ADC PARKS & GREENSPACE ARBORICULTURE

PLANNING APPLICATION: Y/12/15/PL

ADDRESS: The Old Coal Yard North End Road Yapton BN18 0DN

BRIEF DESCRIPTION: Construction of 4No. houses with associated landscaping & parking

Garage and hard-surfacing within the RPA of tree no. T8

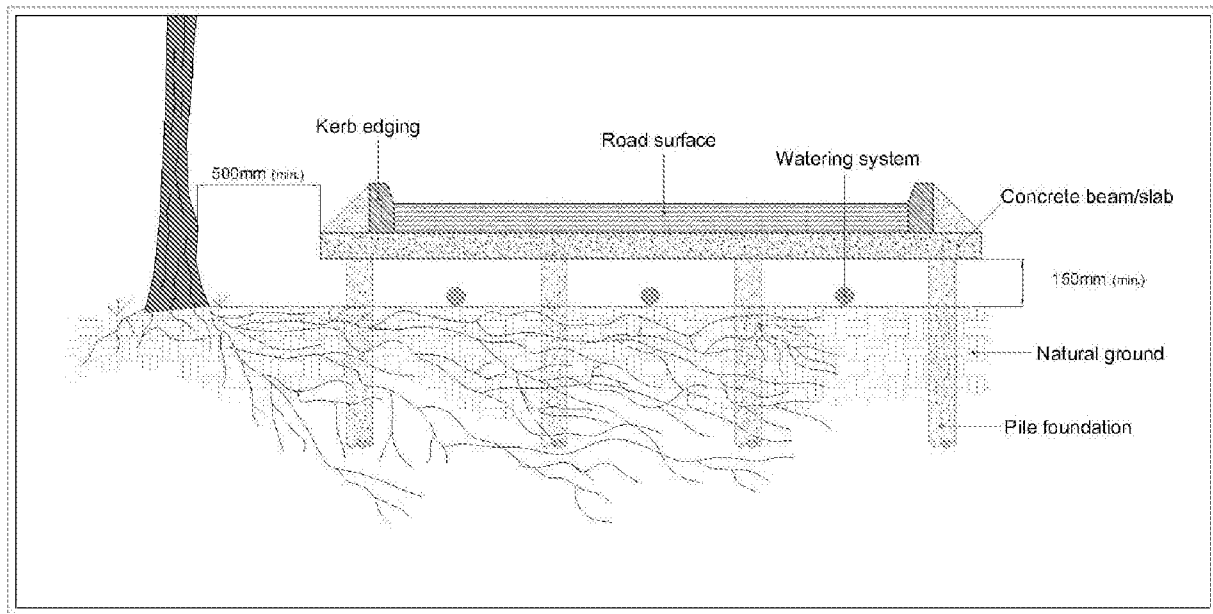
- Although not ideal (due to the size of the area to be surfaced) for the proposed mitigation offered for RPA, main stem and canopy of **T8**, the applicant has correctly cited the differing techniques and materials required. The applicant has also cited the use of a '*watering system is to be designed to either capture rain water and direct it onto the soil below the road deck or for the roadway to be permeable. These systems must take into account that if the surface is to be subjected to de-icing salt, an impermeable barrier or filtration system will be required to prevent contamination of the rooting area*'. Considering the large area of **T8** RPA that is proposed to be used as a driveway (using a hard surface), the use of a watering system and an impermeable barrier/filtration system will be an important aspect of preventing leaching of the soil and keeping **T8** in a healthy condition.

- The applicant must work to specification established in the Tree protection plan (especially when completing the works and mitigation affecting **T8**).
- If any roots are discovered over 25 mm when excavating (for the fence posts along the southern boundary), they are not severed. If the applicant wishes to sever these roots, then ADC arboriculturist must be informed and allowed to supervise any operations.
